Subject: LU/251/19/HH - [REDACTED]

With regard to the above application, I understand the determination date is due 3rd October. Is it possible to substitute the following drawings at this late stage?

0270 / 102 rev C	Proposed floor plans
0270 / 103 rev C	Proposed elevations

client	project	drawing	date	drawn	drawing no	revision
Stephen Hill	Extension at 13 Peregrine Road Littlehampton, BN17 6DT	Proposed elevations	Mar 19	pd	0270 / 103	C
			scale 1:100 @ A3	CAD file name:

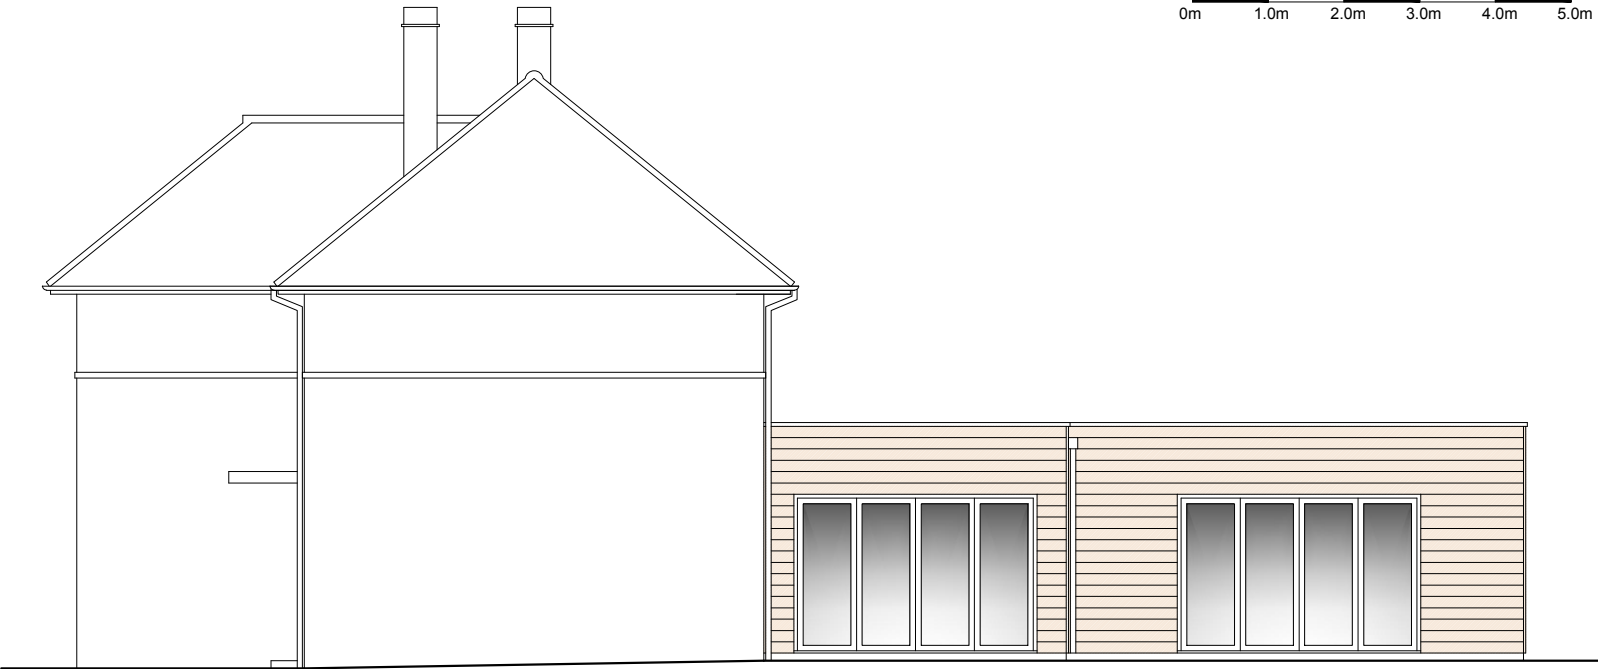
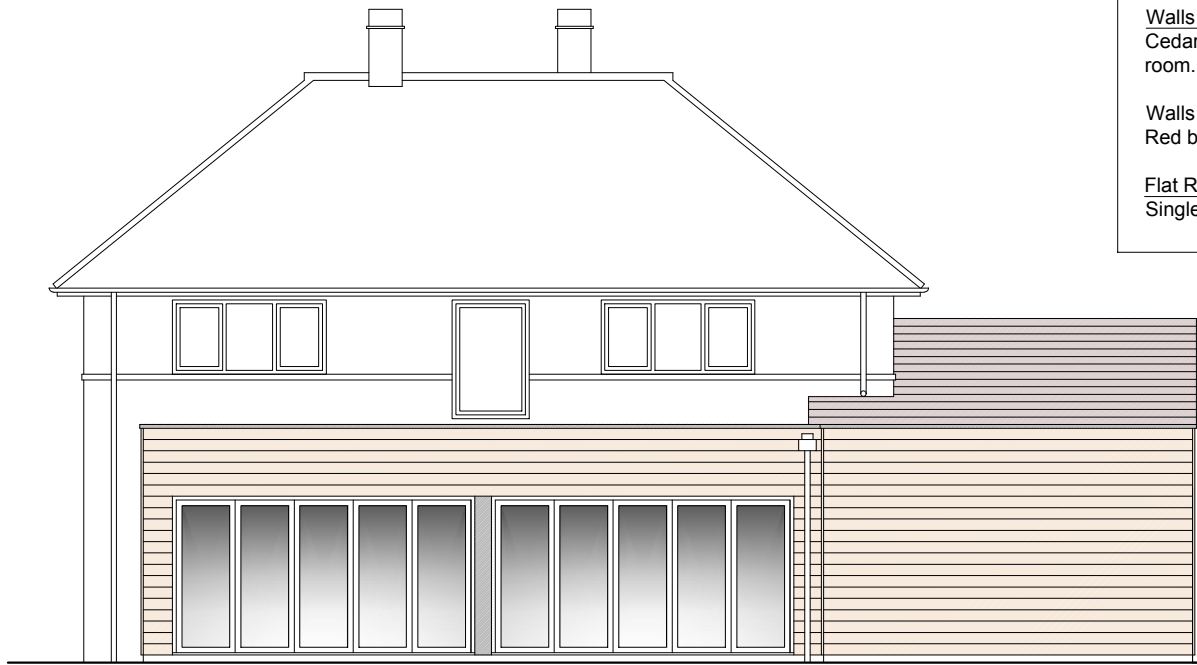
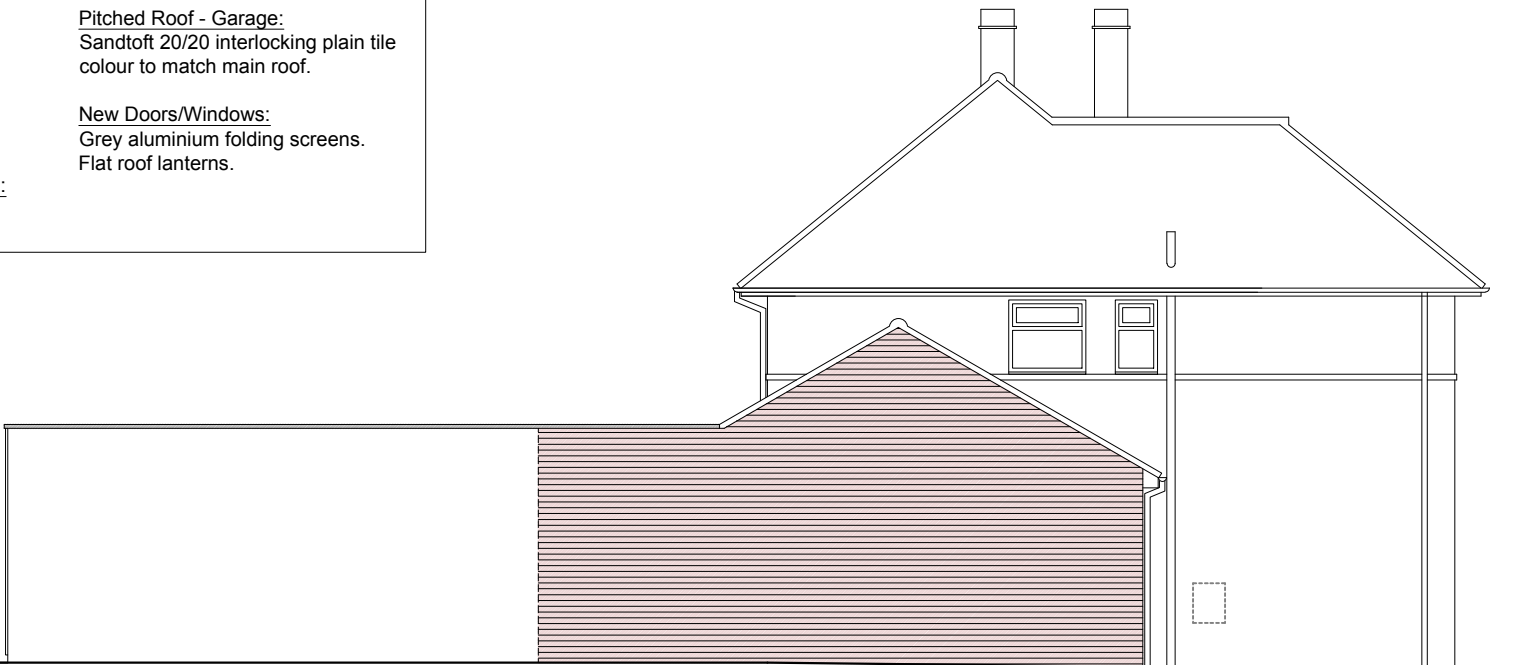
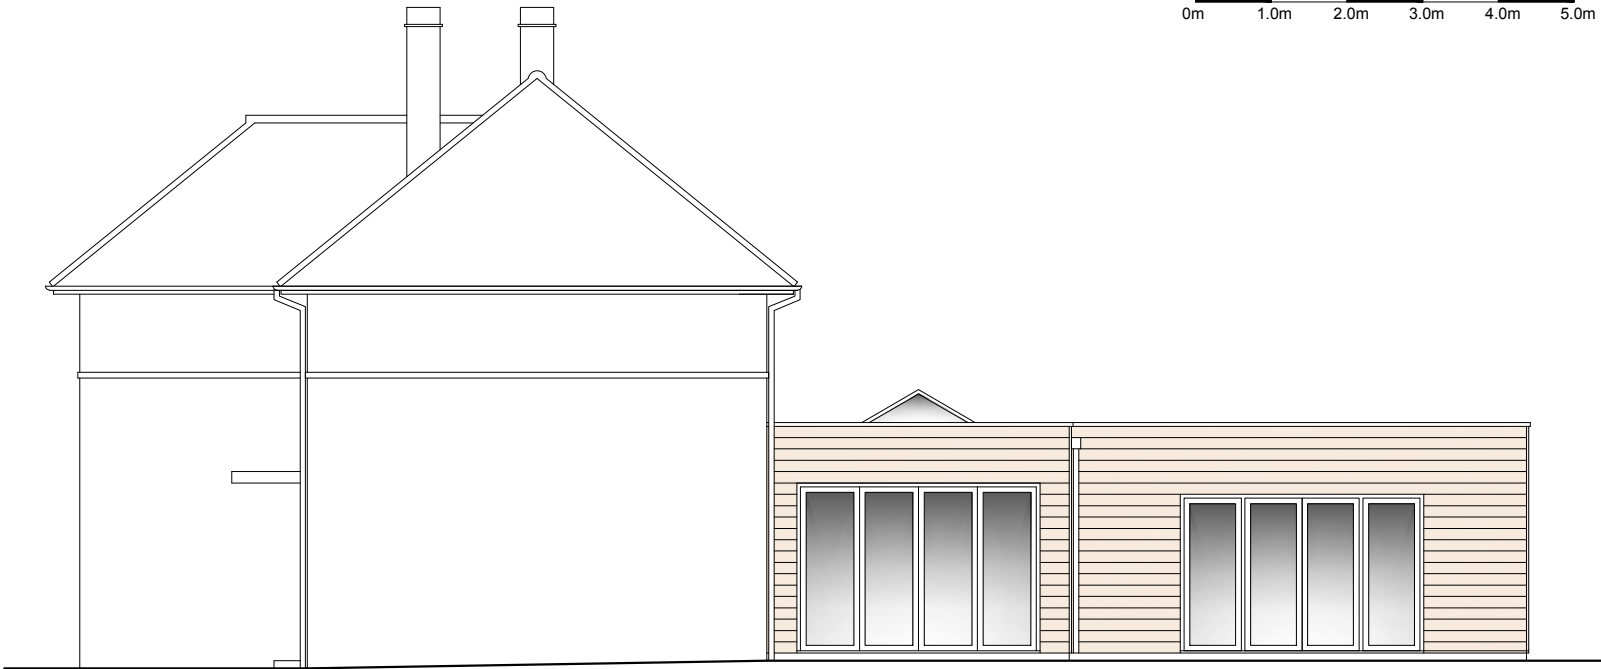
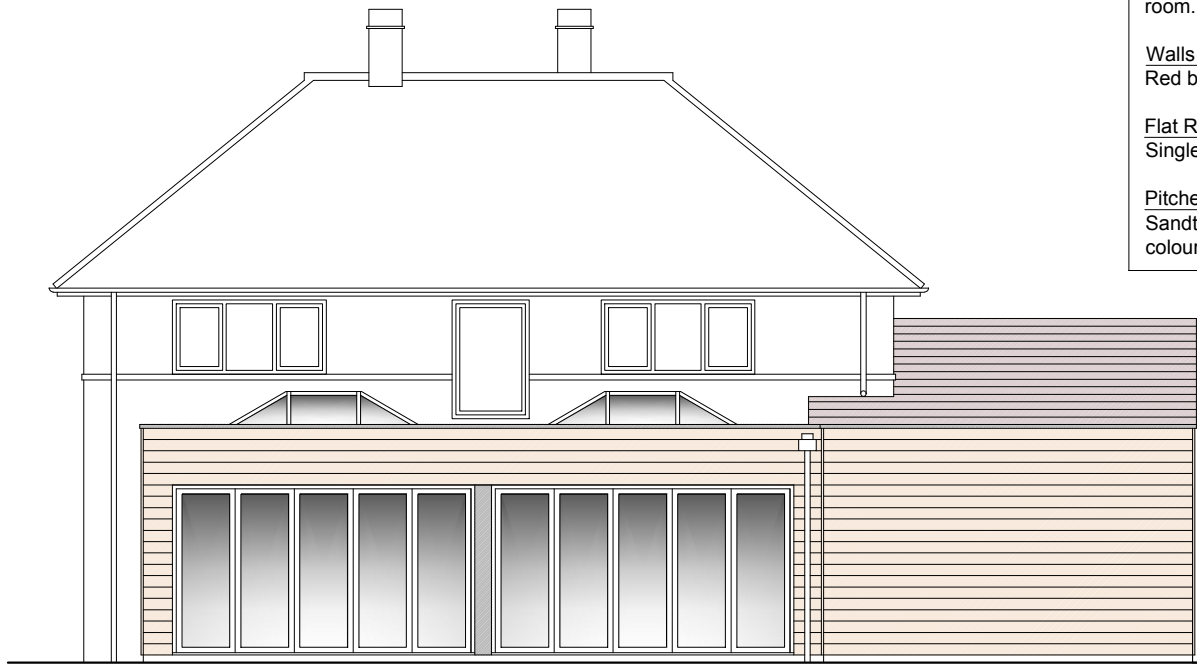
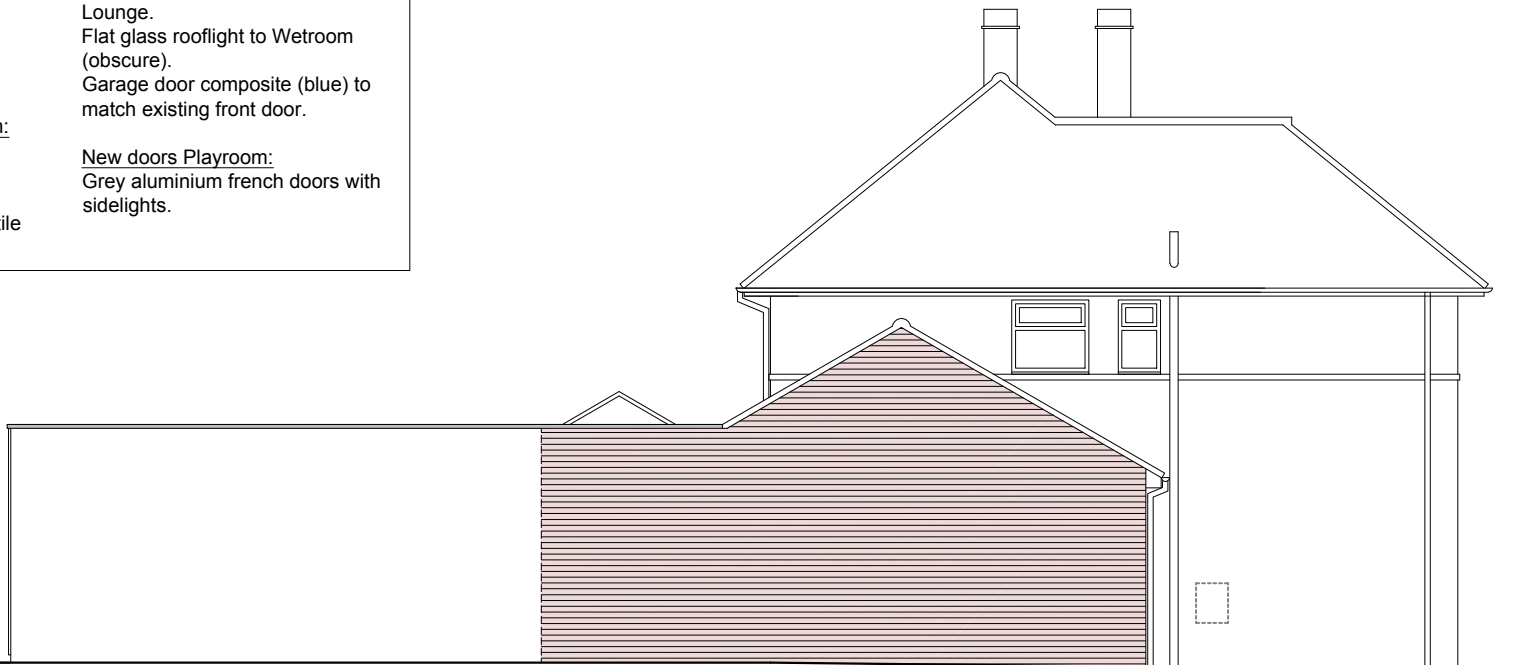
1. Flat glass rooflights changed to traditional lanterns (size unaltered).
2. Small flat glass rooflight added to the Wetroom.
3. Playroom doors changed from folding screen to french doors.
4. Garage door material changed from cedar to blue composite to match existing front door.
